**KIRKLEES METROPOLITAN COUNCIL
INVESTMENT & REGENERATION SERVICE**

Reference No: 2017/62/93976/E

Site Address: Staincliffe Hall, Staincliffe Hall Road, Staincliffe,
Batley, WF17 7QU

Description: Erection of extensions and alterations to detached
garage to create dwelling forming annex
accommodation associated with Staincliffe Hall,
Staincliffe Hall Road, Staincliffe, Batley, WF17 7QU
and erection of detached garage (within the curtilage
of a Listed Building)

DETACHED GARAGE

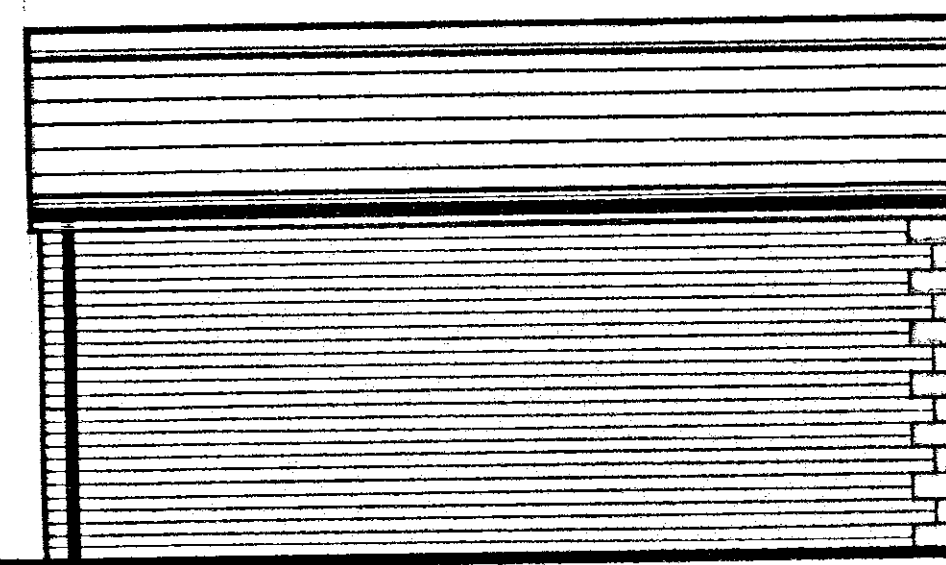
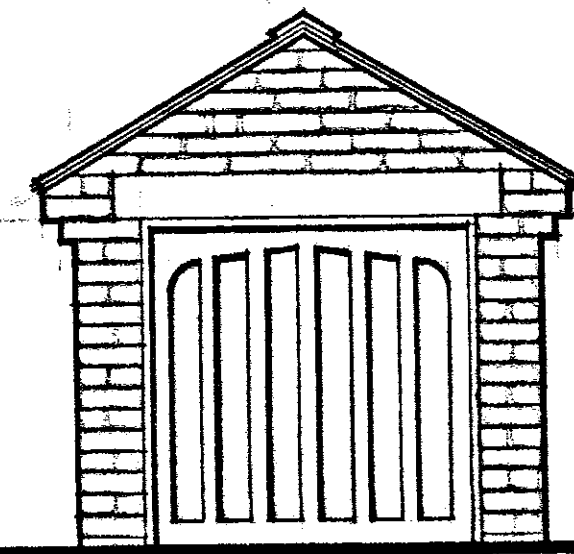
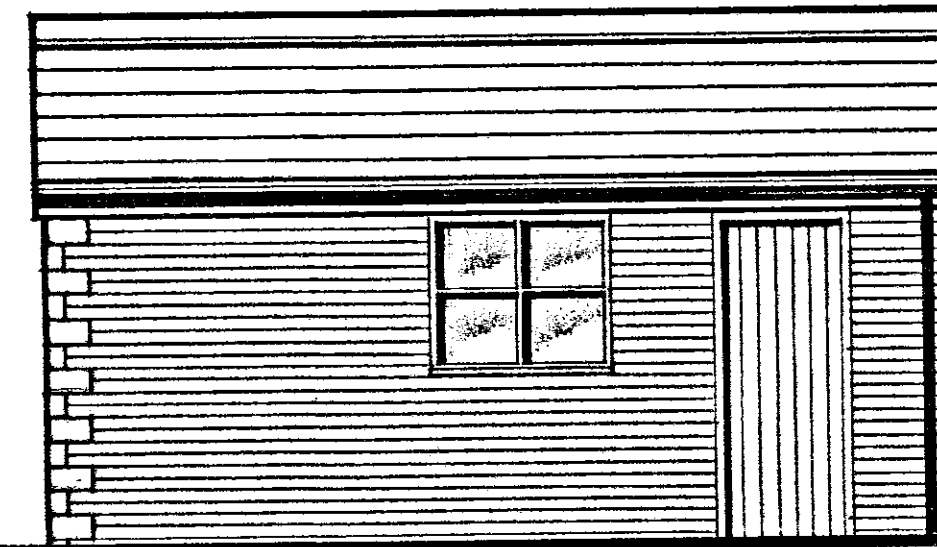
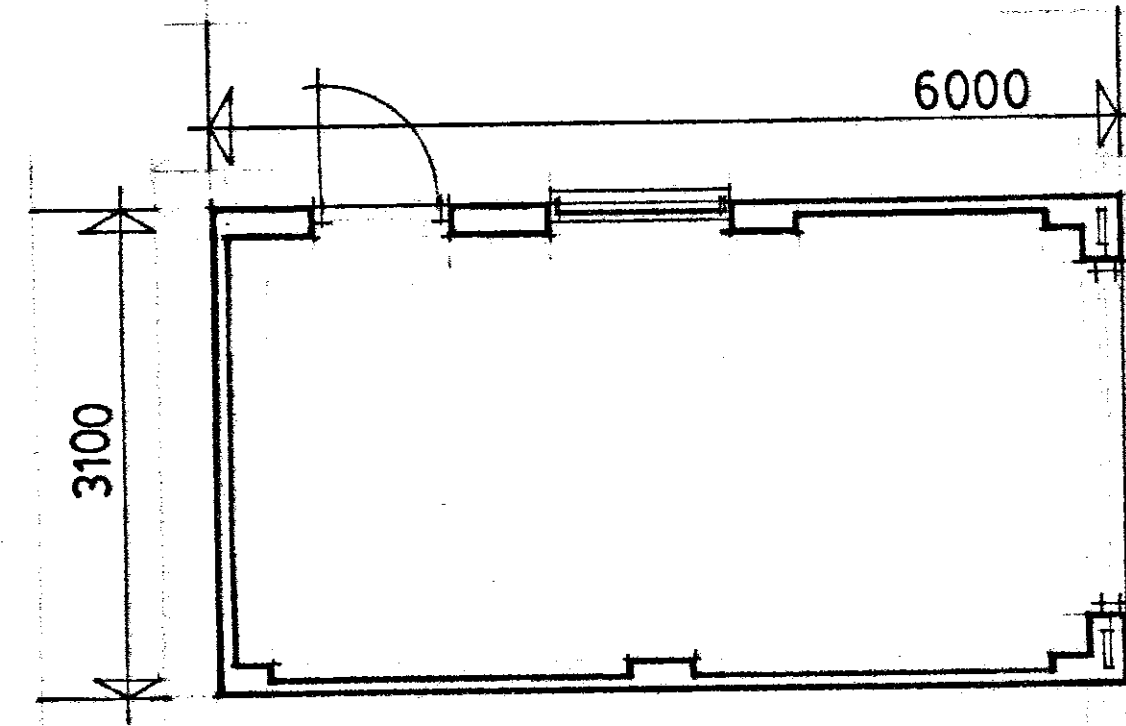
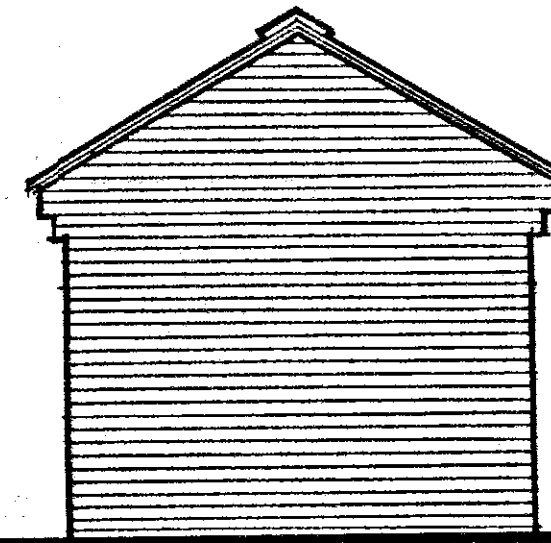
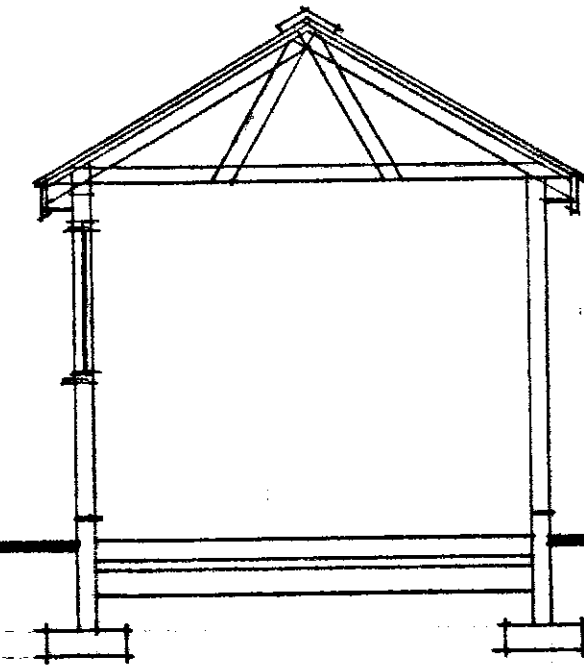
the design of the roof with markedly asymmetric eaves height and length of roof slope together with the increased ridge level and introduction of dormers to the front which are particularly incongruous within the setting of Staincliffe Hall and Cottage.

2. The design of the proposed annex accommodation to Staincliffe Hall with markedly asymmetric eaves height and length of roof slope together with the increased ridge level and introduction of dormers to the front would be incongruous and at odds with the character of the area. This is prejudicial to visual amenity and contrary to Policies D2, BE1 and BE2 of the Kirklees Unitary Development Plan, Policy PLP24 of the Kirklees Publication Draft Local Plan, and the aims of chapter 7 of the National Planning Policy framework.
